An
Bord
Pleanála

Board Direction
BD-009025-21
ABP-310327-21

The Board decided to grant permission generally in accordance with the Inspector's recommendation, for the following reasons and considerations, and subject to the following conditions.

Block 09 and 10 Level 00 Floor Plan

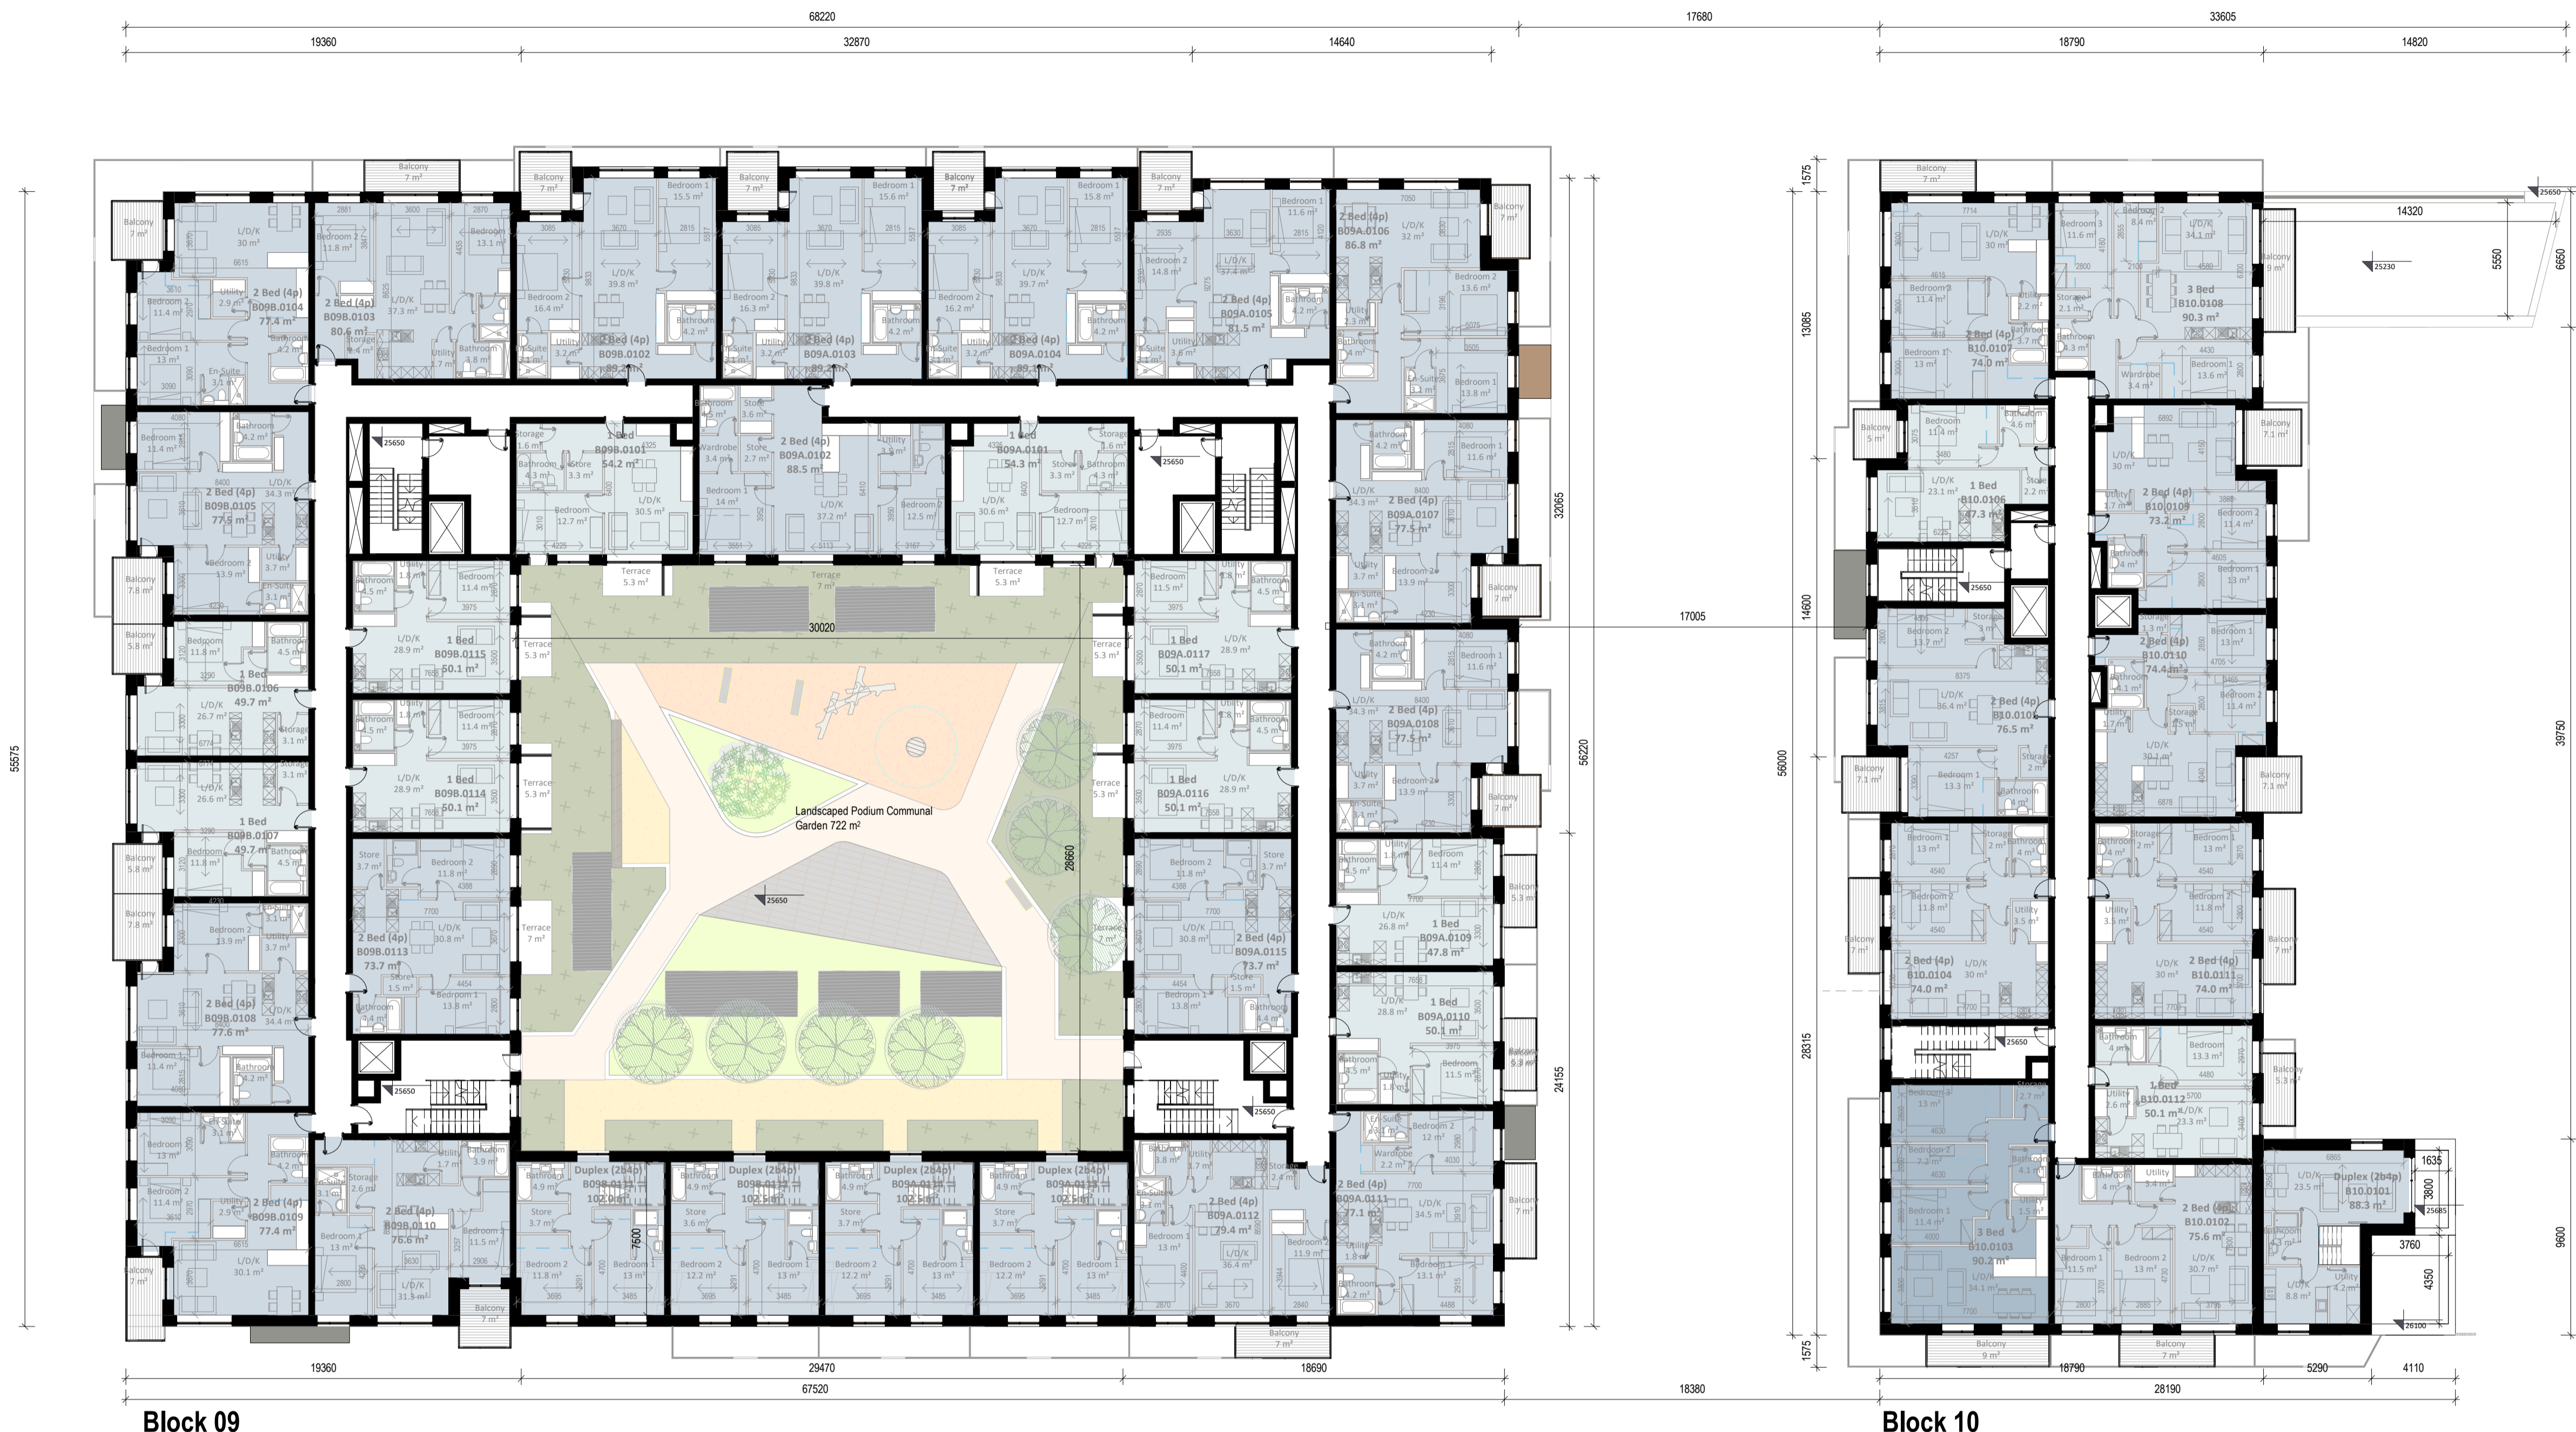
3. The proposed units B09B.GU01, B09A.GU01 and B09A.GU02 at the ground floor level of Block 09, as indicated on drawing No 19045-OMP-ZA-00-DR-A-1000, shall be replaced with a unit(s) accommodating uses permissible under class 1, 2 and 8 of Part 4, Schedule 1 the Planning and Development Regulations, 2001 (as amended).

Revised drawings showing compliance with these requirements shall be submitted to, and agreed in writing with, the planning authority prior to commencement of development.
